LEPPINGTON (1) 88 DEVELOPMENT PTY LTD

BCA ASSESSMENT REPORT

Leppington Site A

Project number: 120011
Revision: BCA Site A 1.0
Date: 28 May 2026

0
-
LOWER GROUND
1:500

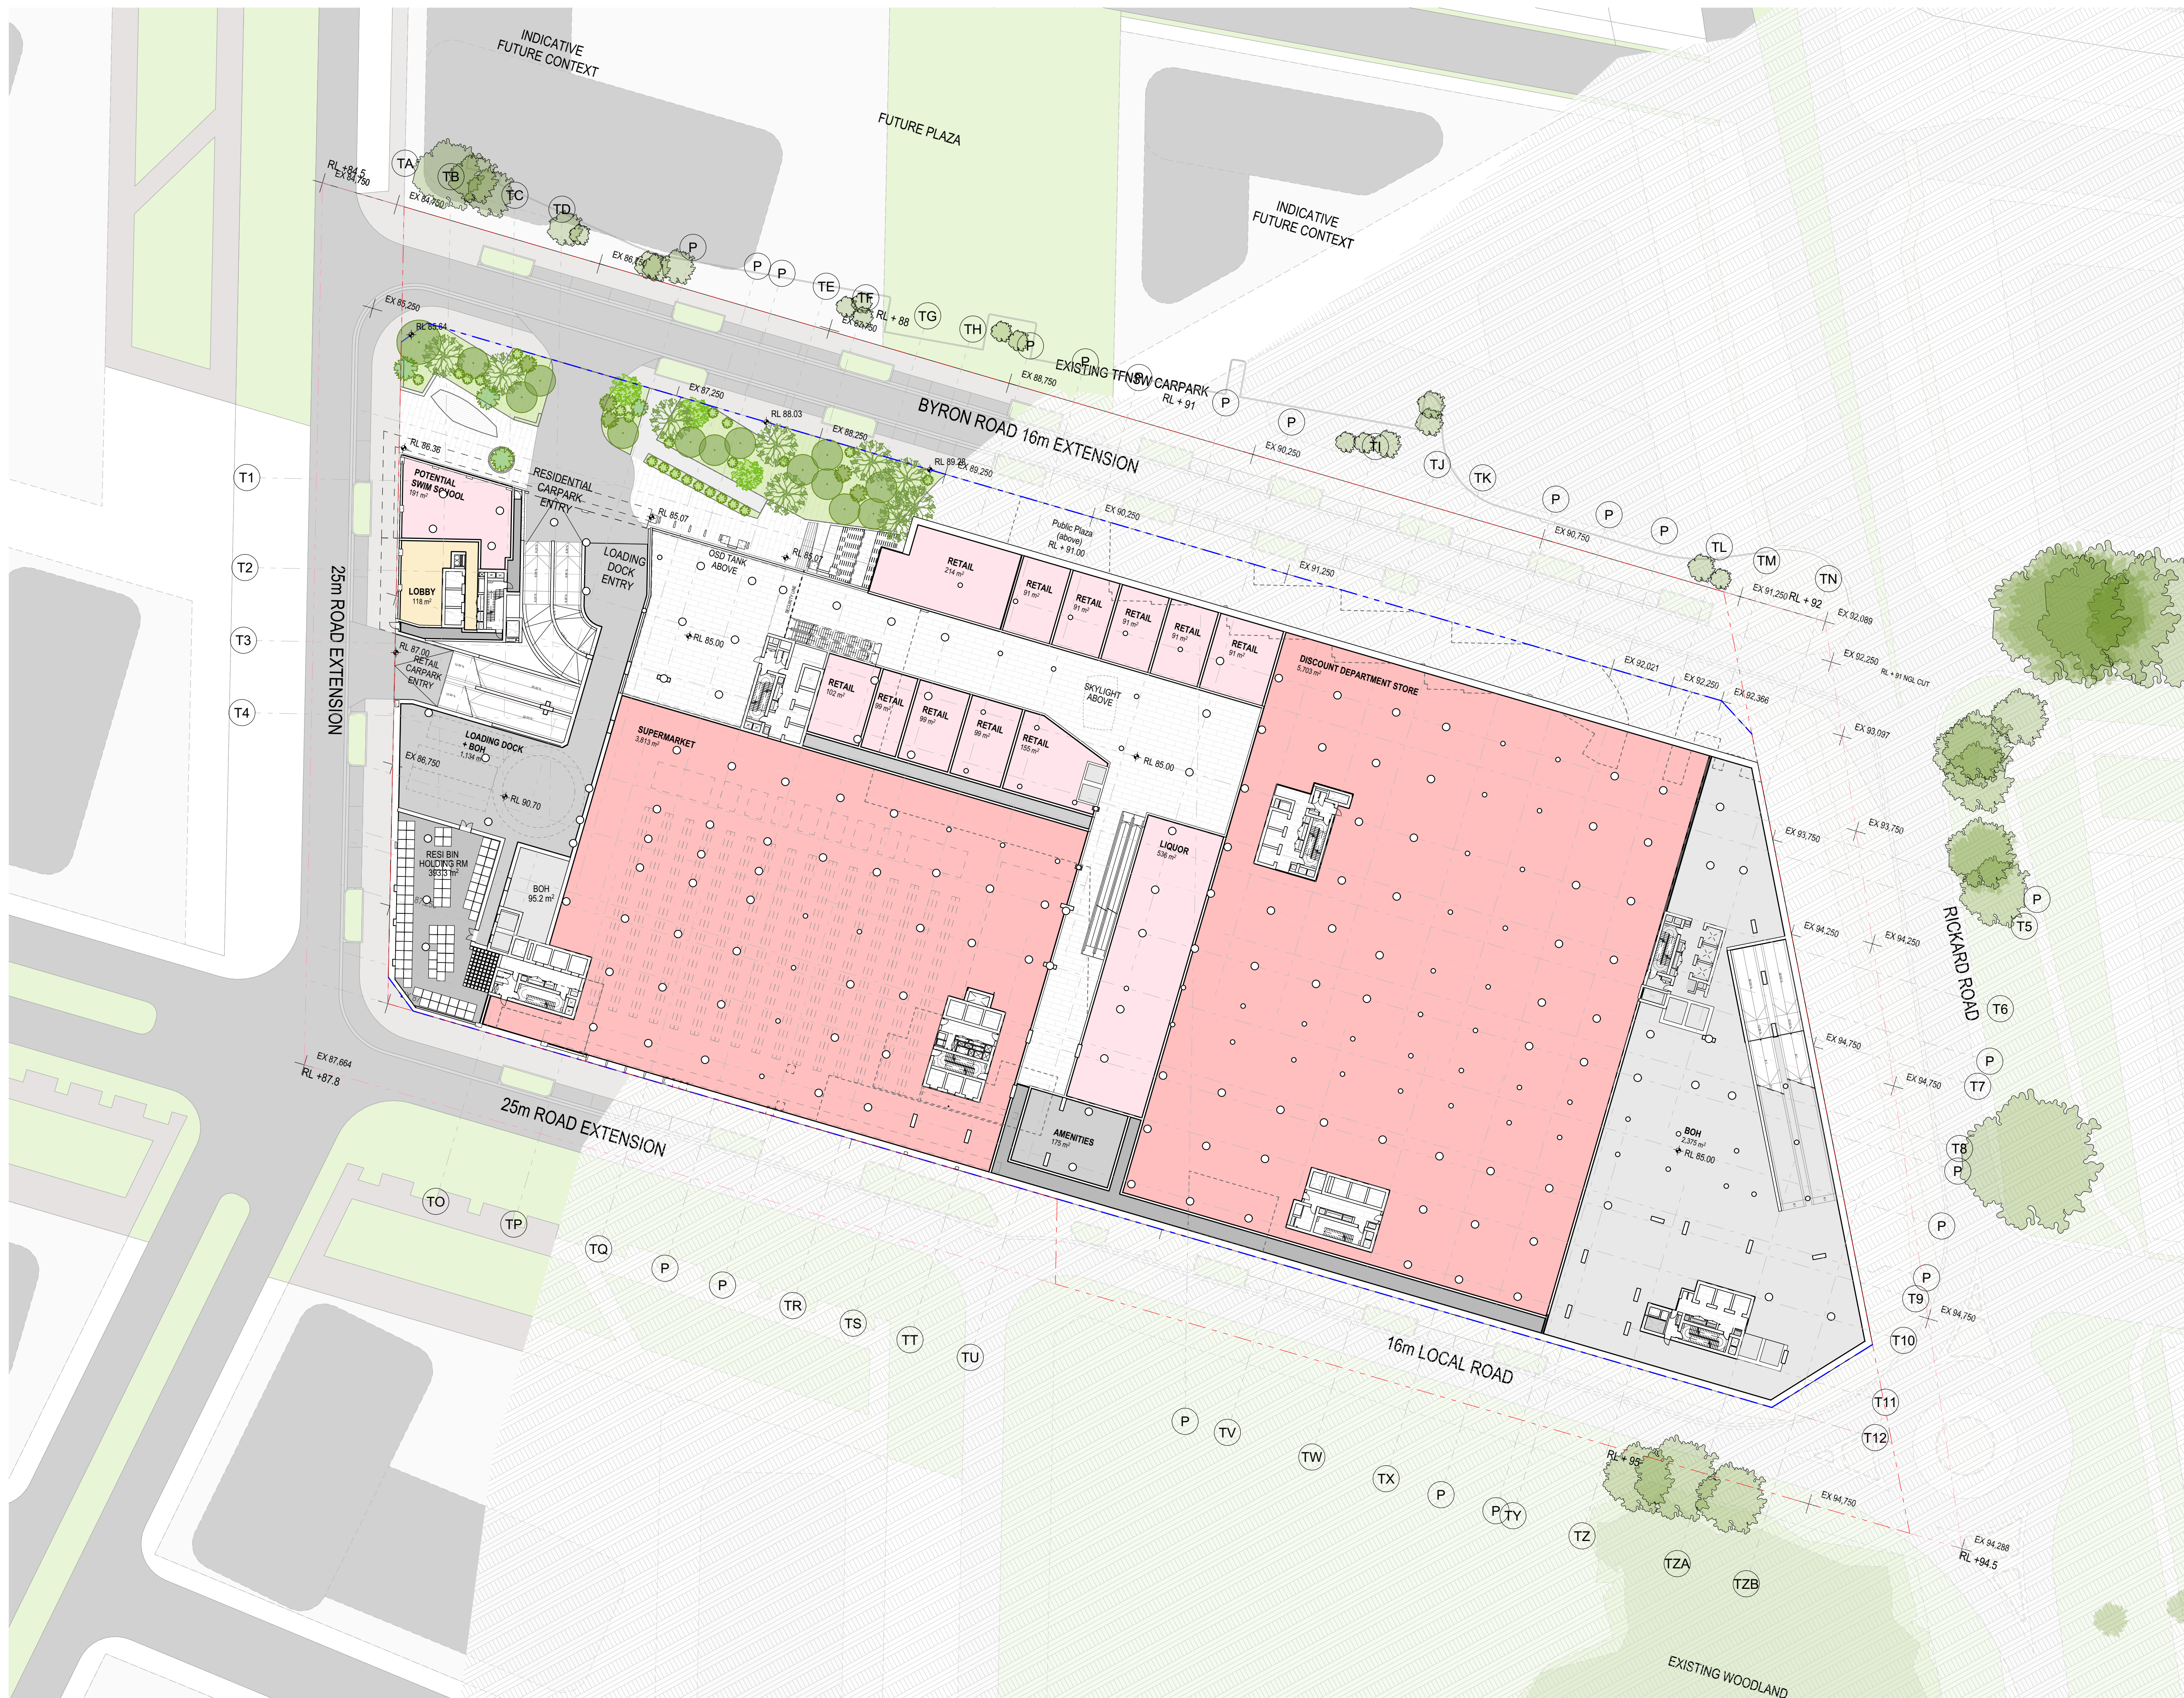
2. Basement Level 01 to 03: The travelators on these parking levels are connected directly with the Lower Ground retail shopping centre meaning they are forming part of the retail fire compartment. The areas around the travelators will be enclosed with a combination of fire walls and non-fire rated construction (glazed construction) in lieu of fire walls required to separate different classifications of Class 6 retail and Class 7a car park.

4. Basement Level 01 & Lower Ground: The swim school tenancy shall be fire separated from surrounding parts to be a separate fire compartment.
5. Lower Ground: The loading dock and bin holding room shall be fire separated from surrounding parts to be separate fire compartments.
